**Your ref:** 3/2021/0275  
**Our ref:** DC/21/1403  
**Date:** 10-NOV-21

**Location:** Land behind The Dog Inn, Market Place, Longridge PR3 3RR  
**Proposal:** Proposed erection of 9 new dwellings and associated works

#### **Request for Additional Information Prior to Determination**

Longditudinal Section along runoff path
1 : 50

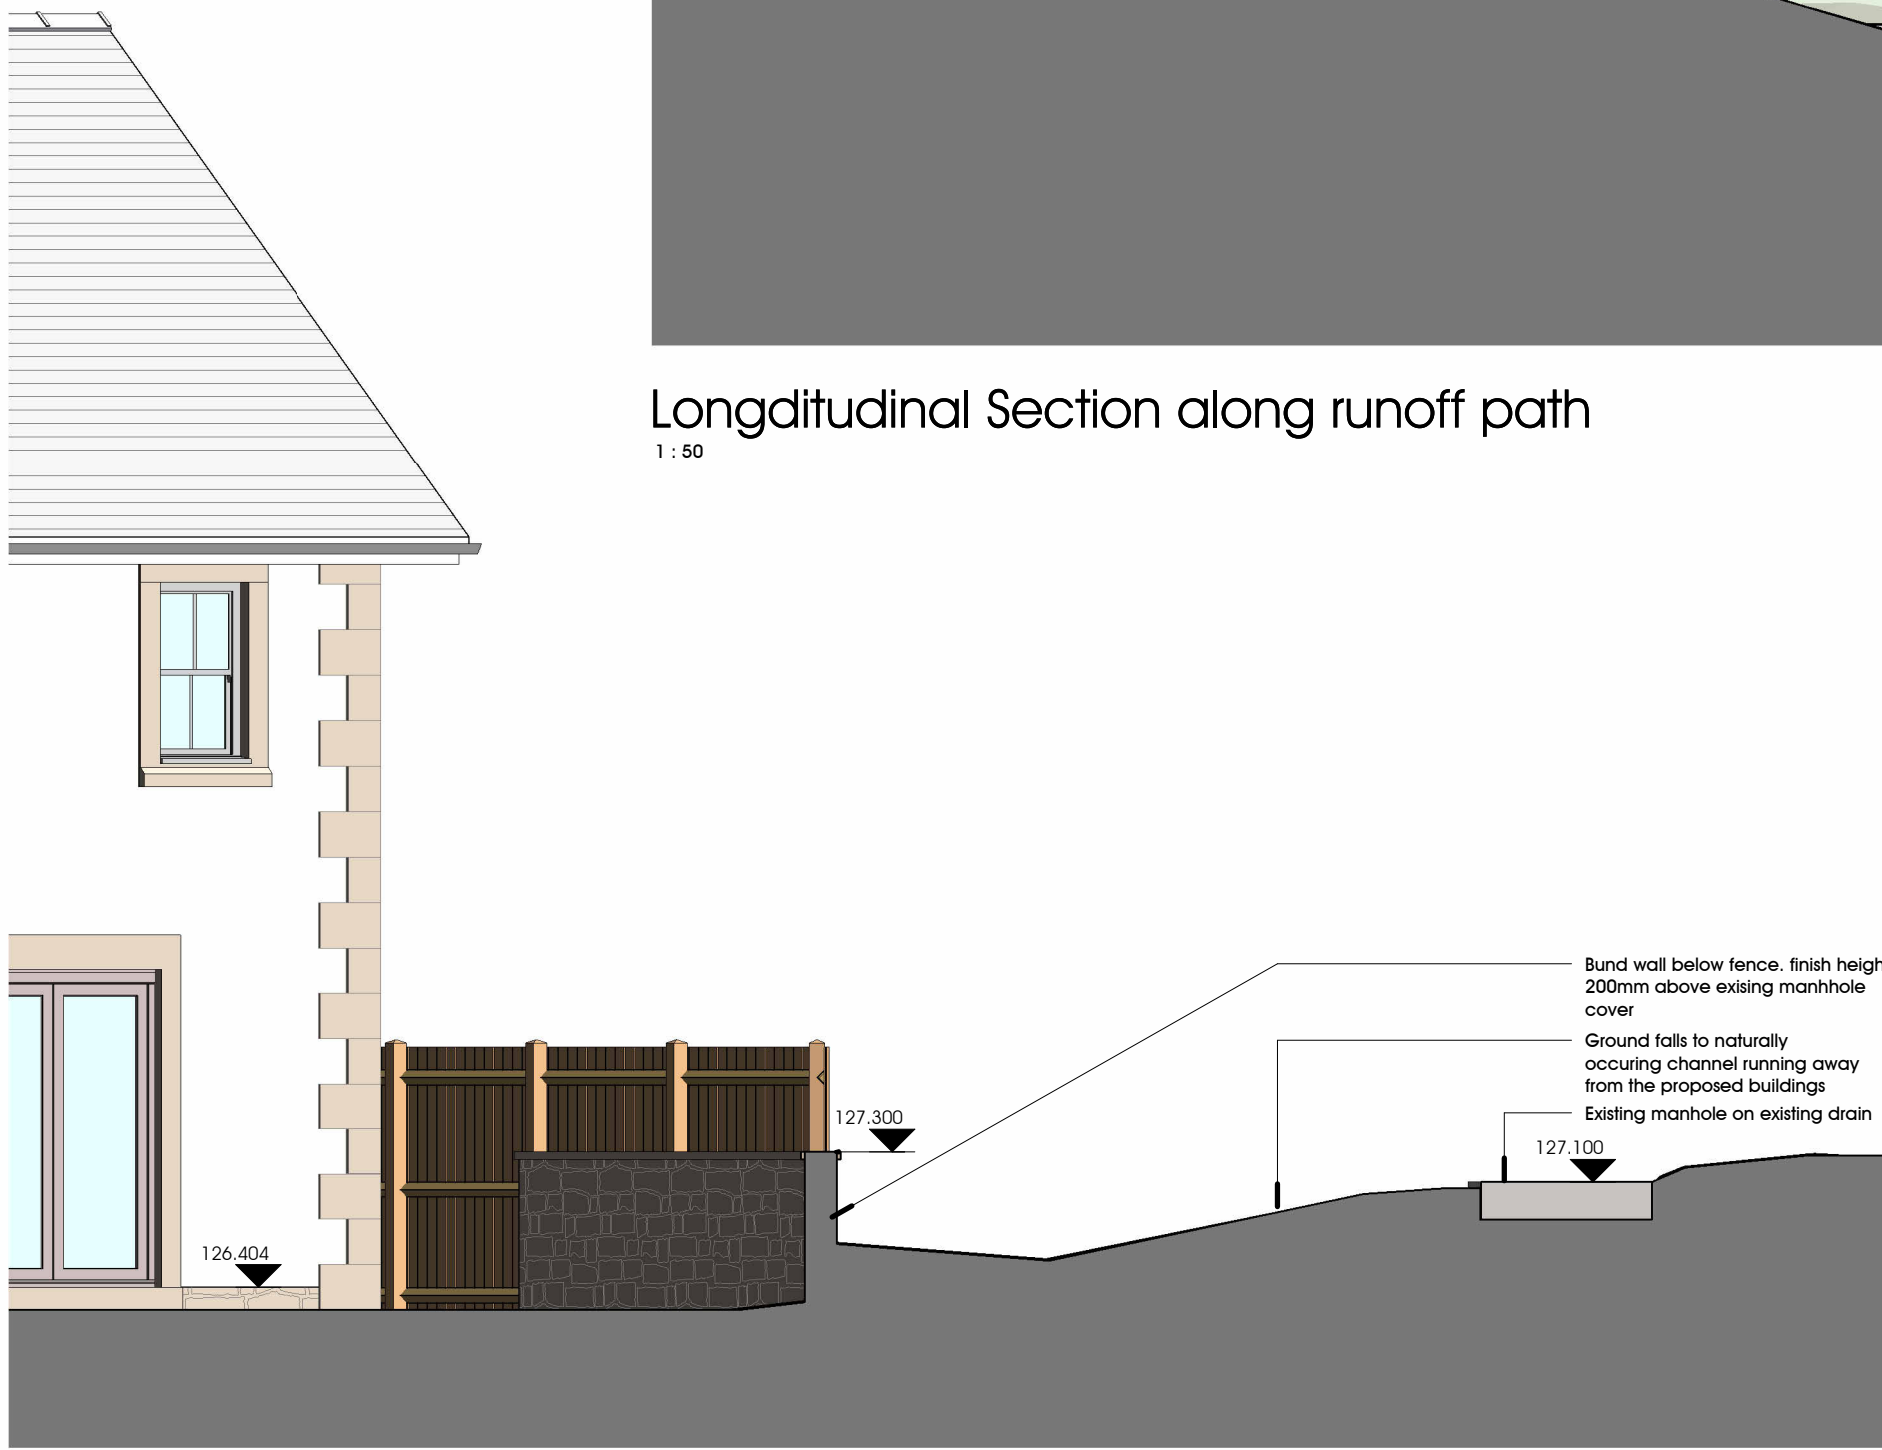
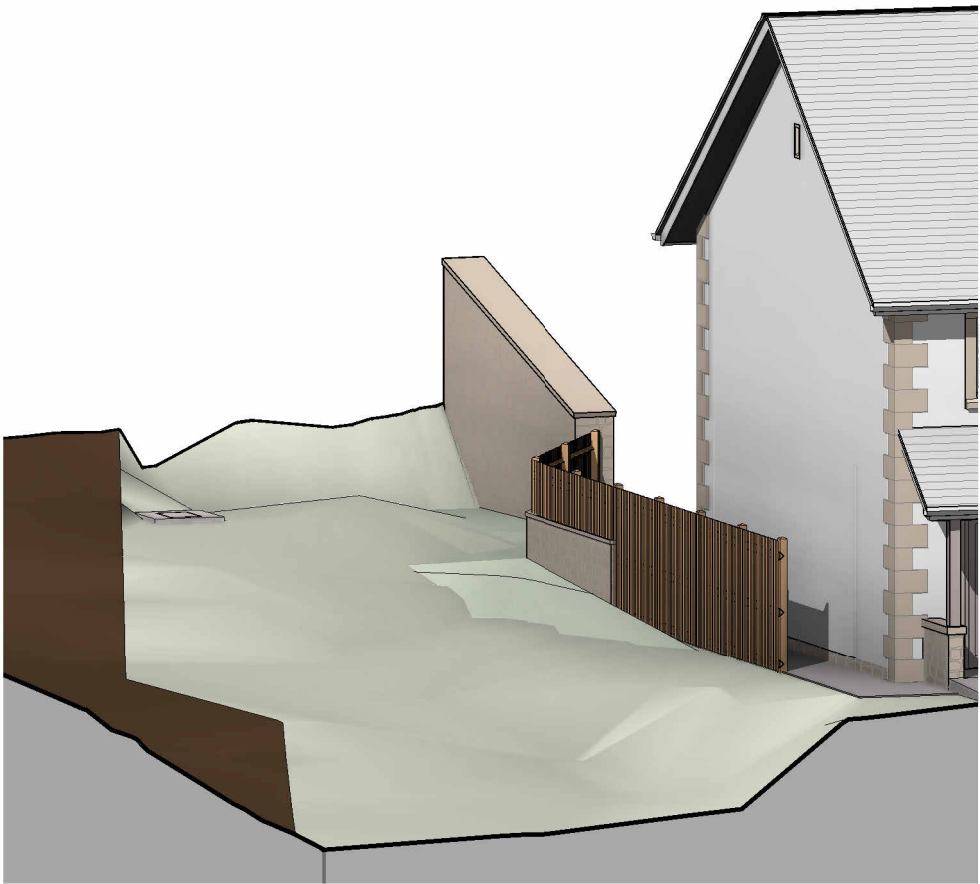
2. We note that the consulting engineers have now included details of exceedance flow routes on the revised design, however, there is no evidence to show that flows will be conveyed in the highway rather than continuing towards existing properties to the southeast. We request that the applicant provides details to demonstrate how any exceedance flows will be managed in

practice for example through high kerbs and any raising of proposed ground levels. This information should be included on the provided drainage plan, which should also include final finished ground levels as noted above. We request that the applicant clarifies the details for any retaining wall structure and boundary treatment around the curtilage of the proposed properties. This is particularly with reference to plots 1 and 7. We request that the external ground levels fall away from the curtilage of the proposed properties (following any regrade) to allow for safe overland / exceedance flow routes.

Proposed Site Plan
1 : 200
0 1 5 10m

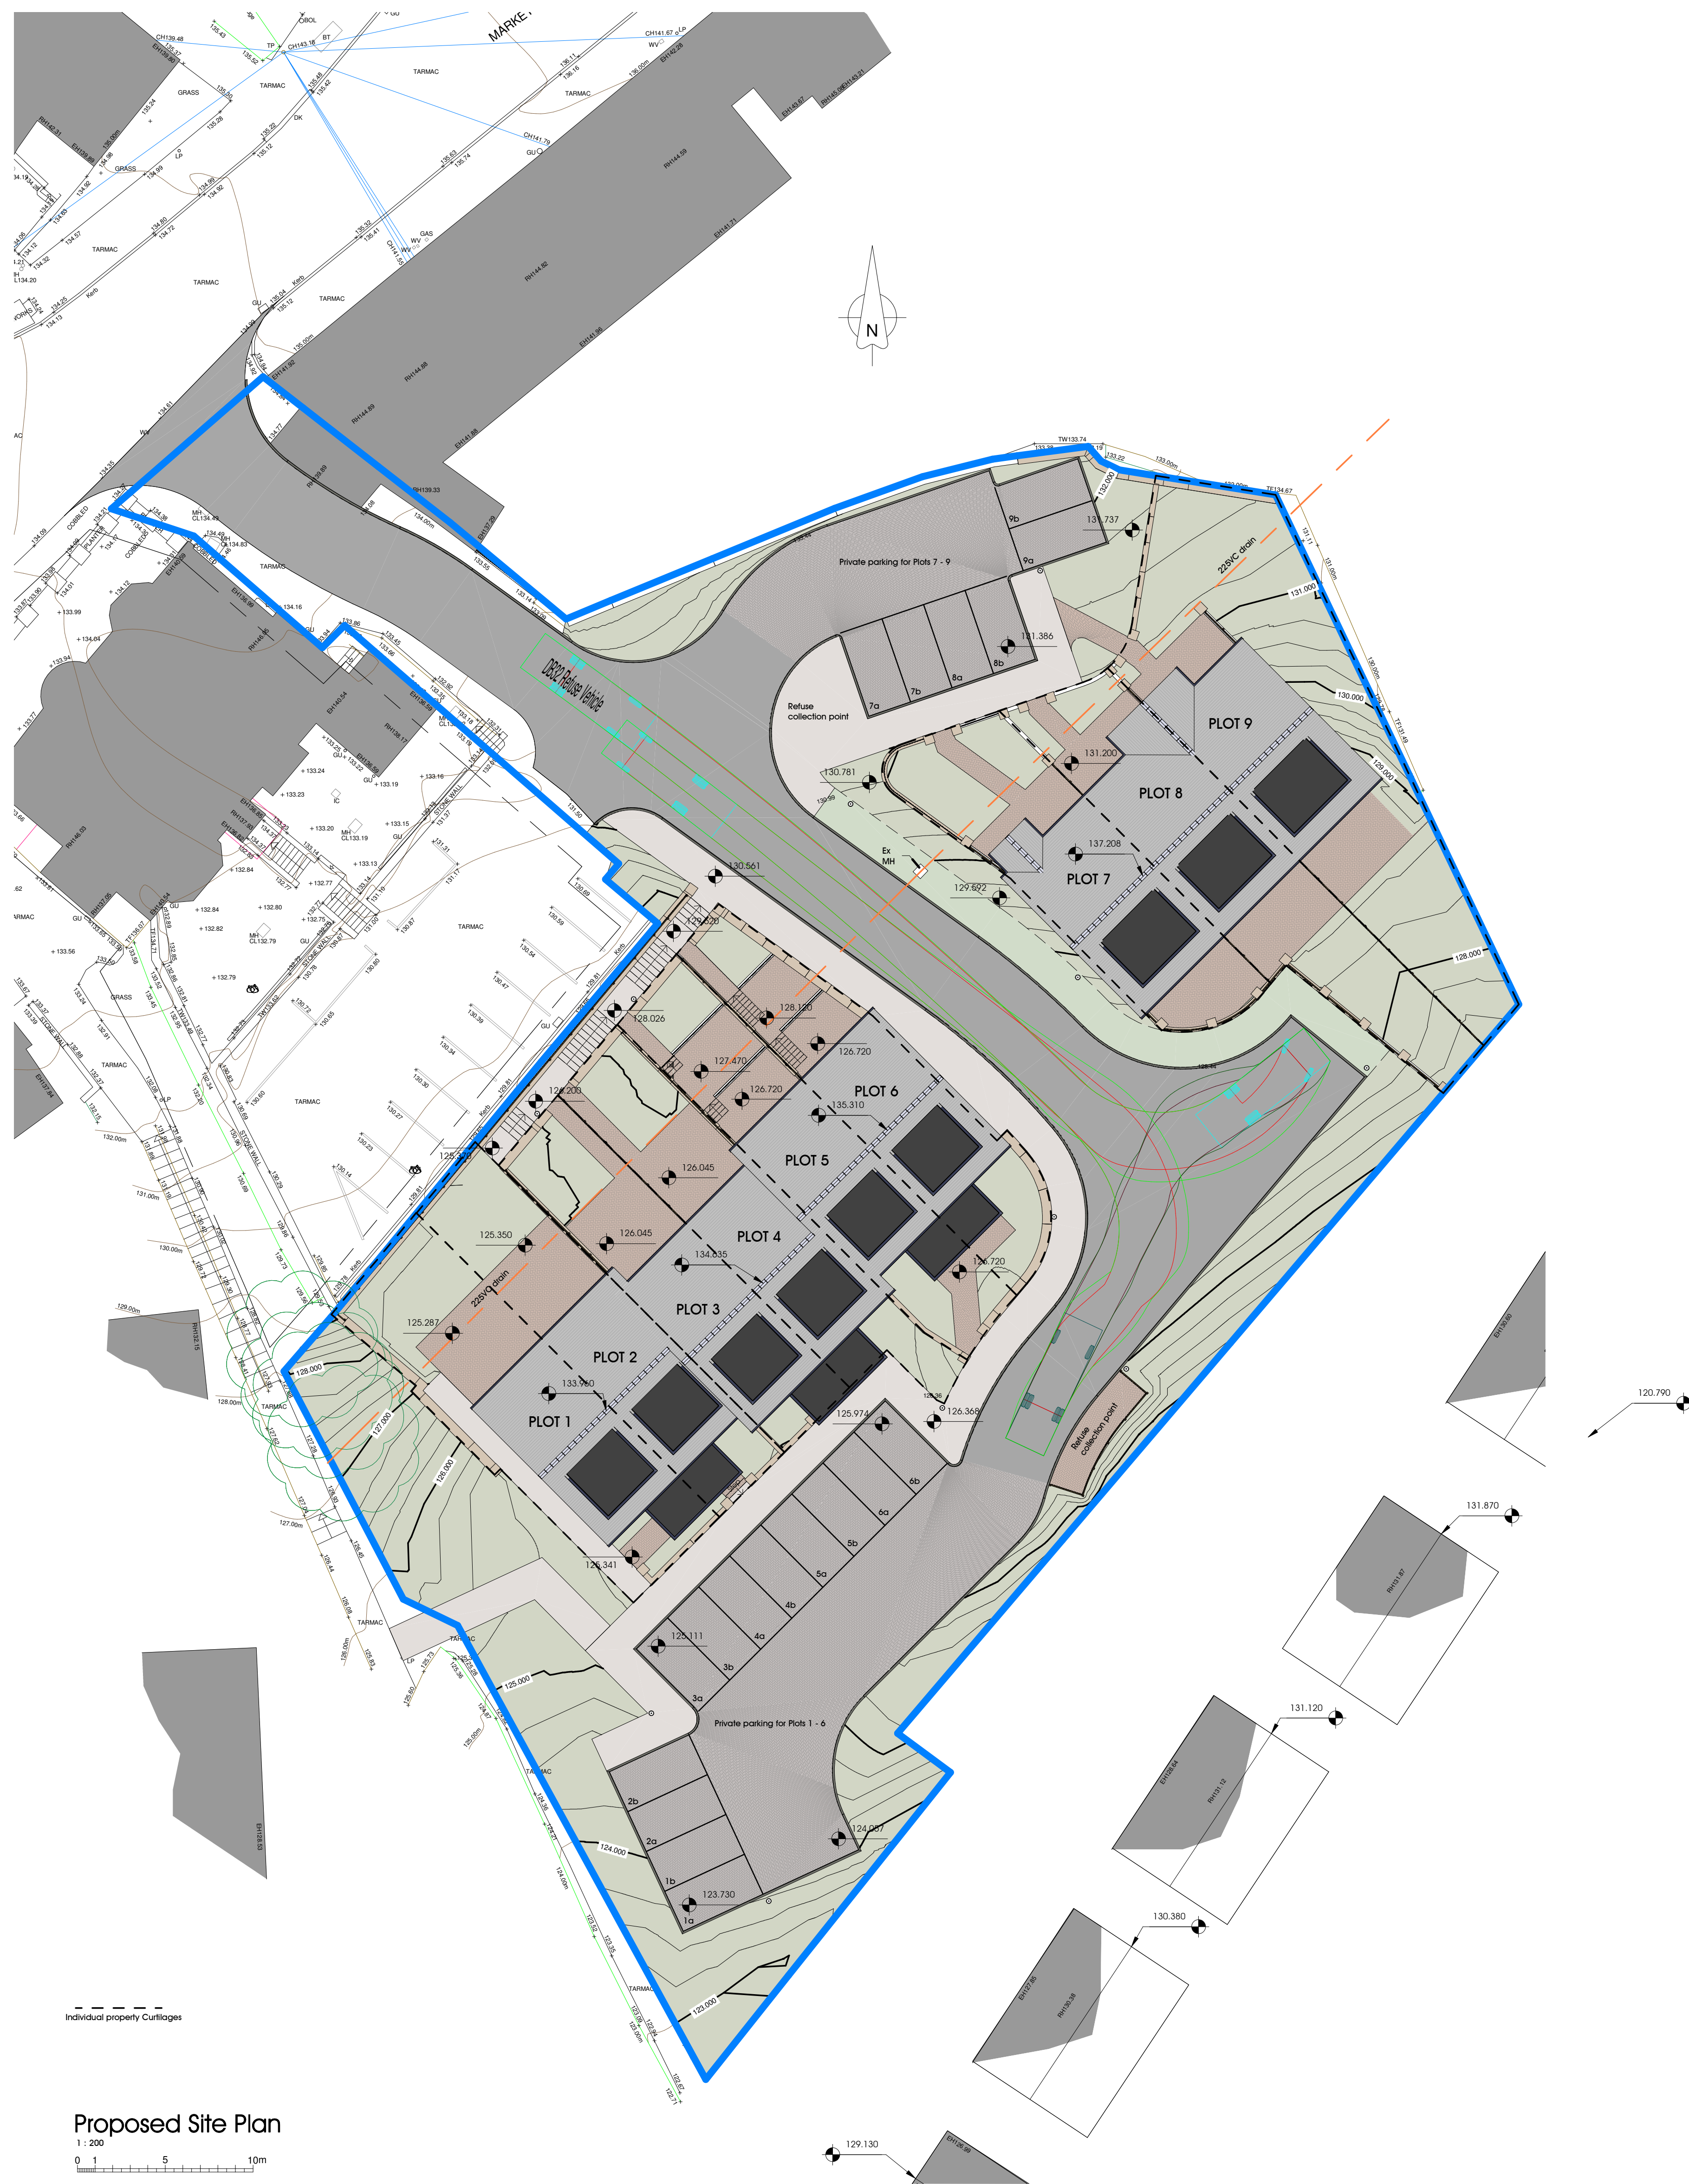
1. With respect to the finished floor and ground levels, whilst spot ground levels surrounding some of the proposed properties have been provided (as well as the levels of ridge lines), we would request that the applicant confirms the finished floor levels for all proposed units and finished ground levels for the site. In addition, the drainage strategy plan only provides a limited level of information for assessment of the proposed drainage system. There are no details for the surface water drainage arrangements and only partial information for the foul drainage system. We have requested this information previously and still require this detail in order to make a full assessment of the proposals. We request that the information includes the proposed private drainage runs and connection points for each unit to the proposed drainage systems in order to complete our assessment of the proposed development.

4. We can see from the information provided that both manholes on the proposed private drainage run will be of relatively deep construction but the pipe linking the two will have minimal cover. This is a risk that the developer/ultimate owner will have to be informed of, but if it is a private system, it would not be subject to the same adoption criteria. It would still be subject to Building Regulations and subsequent sign off from an approved Building Control Officer.
